MEMORANDUM

TO: Nell Donaldson, Planner
FROM: Lauren Swett, PE
DATE: August 23, 2016
RE: 30 Merrill Street, Level III Site Plan Application

Woodard & Curran has reviewed the Site Plan Application for the proposed development located at 30 Merrill Street in Portland, Maine. The project involves the construction of a four story residential building with parking in the rear of the lot.

PERVIOUS PAVEMENT SECTION DETAIL
NOT TO SCALE

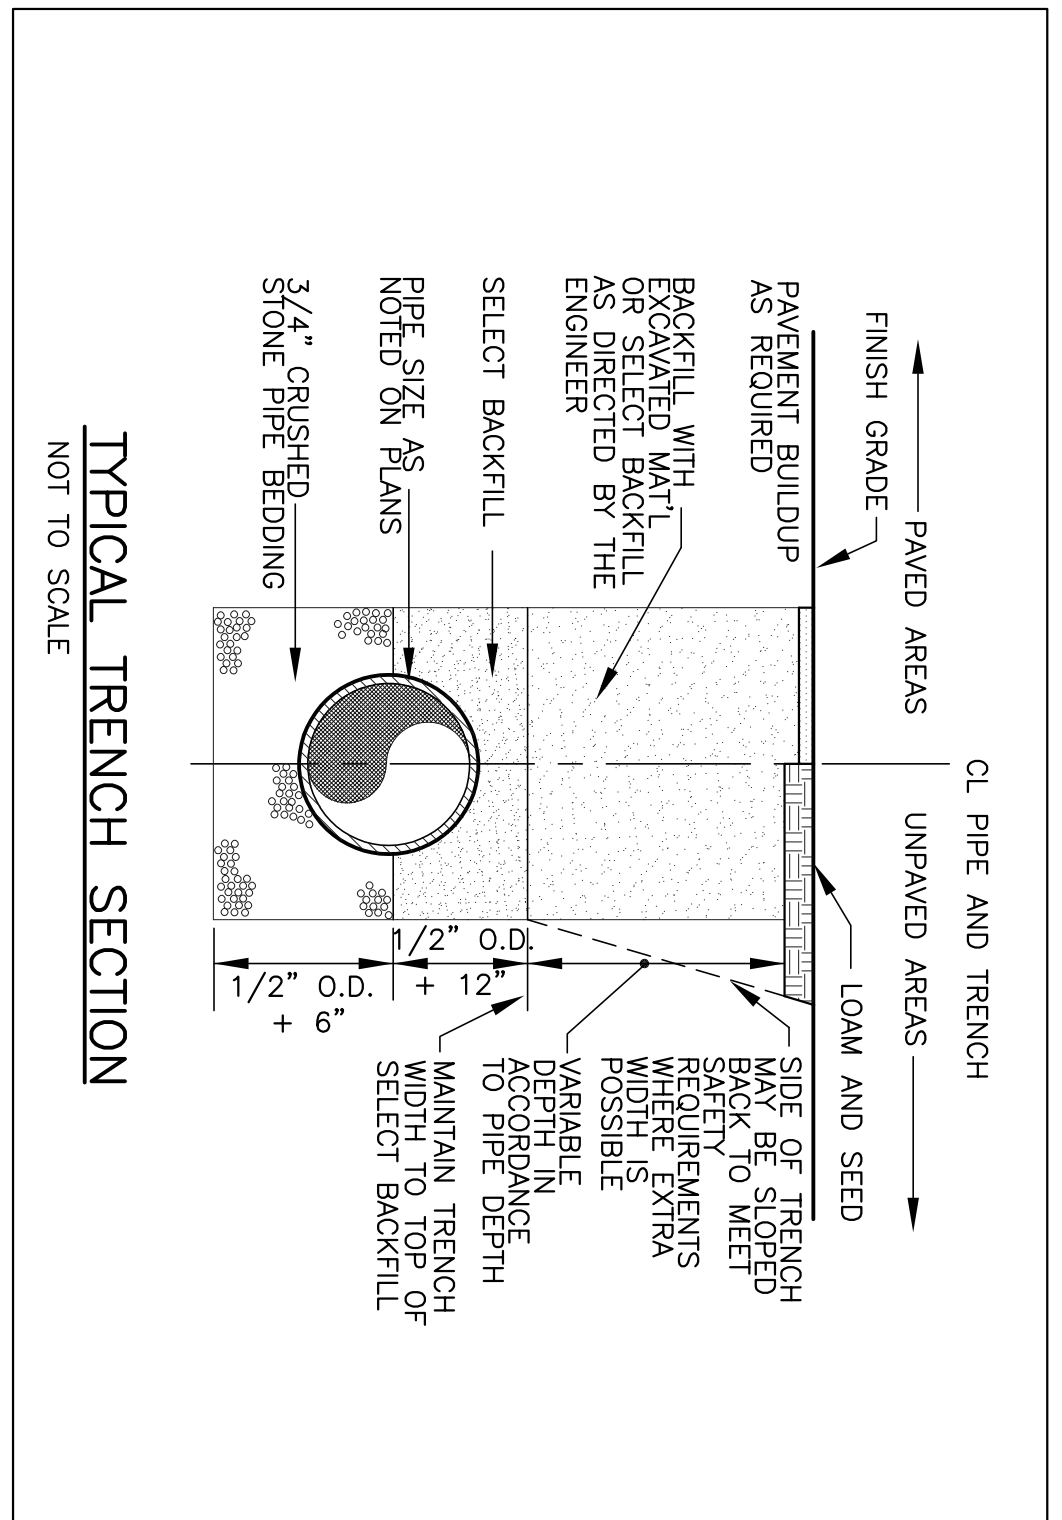
- The Pervious Paver Section Detail provided on Sheet C2 includes a Filter Layer; however, the Site Plan and stormwater management plan indicate that the limit of the proposed filter bed does not extend over the full area of proposed pervious pavers. A detail should be provided for paver installation in areas outside of the filter bed, to confirm that the entire paver area may be considered pervious. If the additional pavers are not installed in such a way that they are pervious, the impervious surface calculations should be updated, and the filter area should be designed per the Maine DEP Stormwater BMP manual's guidance for "Run-On Modular Pervious Pavement."

- The Applicant should provide information on the depth to groundwater and bedrock in the area of the proposed pervious pavers.
 - The Pervious Paver Section Detail should include specifications for the filter layer per Chapter 7.7 of Volume III of the MaineDEP Stormwater BMP Manual.

- 3) The Applicant should provide a detail for pipe trenches, brick sidewalk repair, and pavement repair within the City of Portland Right-Of-Way per the City of Portland Technical Manual.

SEWER / FOUNDATION DRAIN SERVICE CONNECTION
NOT TO SCALE

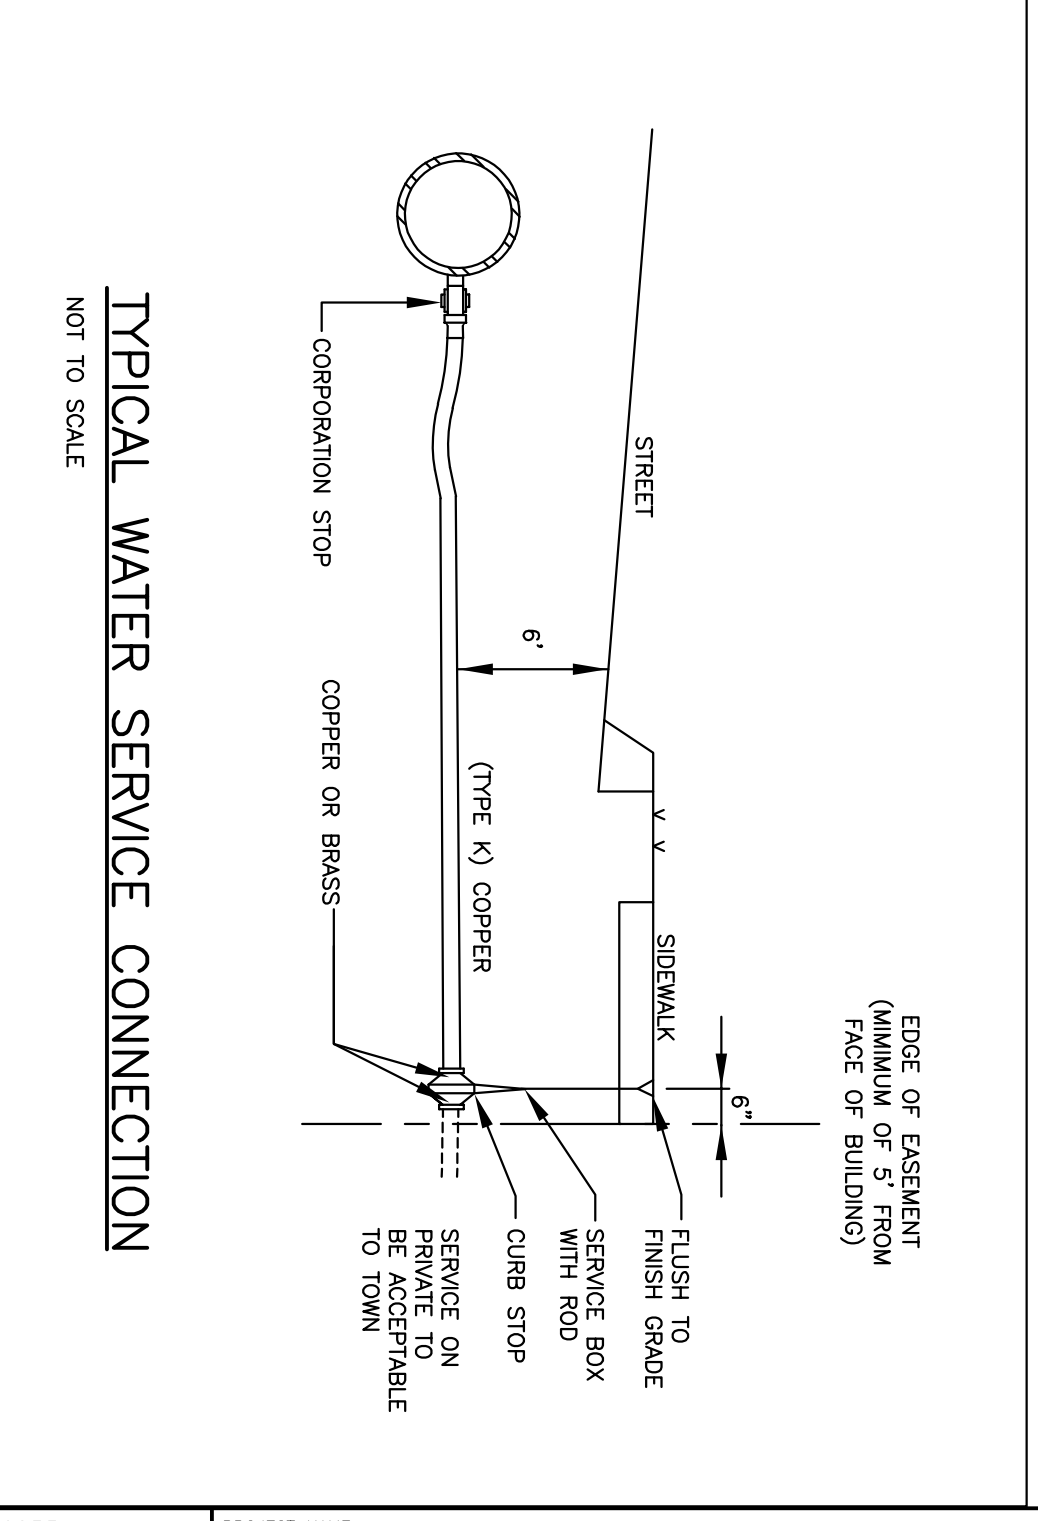
- 4) It appears that the Applicant is proposing to abandon an existing sanitary sewer service connection and install a new one. The Applicant should clarify what methods will be utilized to abandon the existing connection.
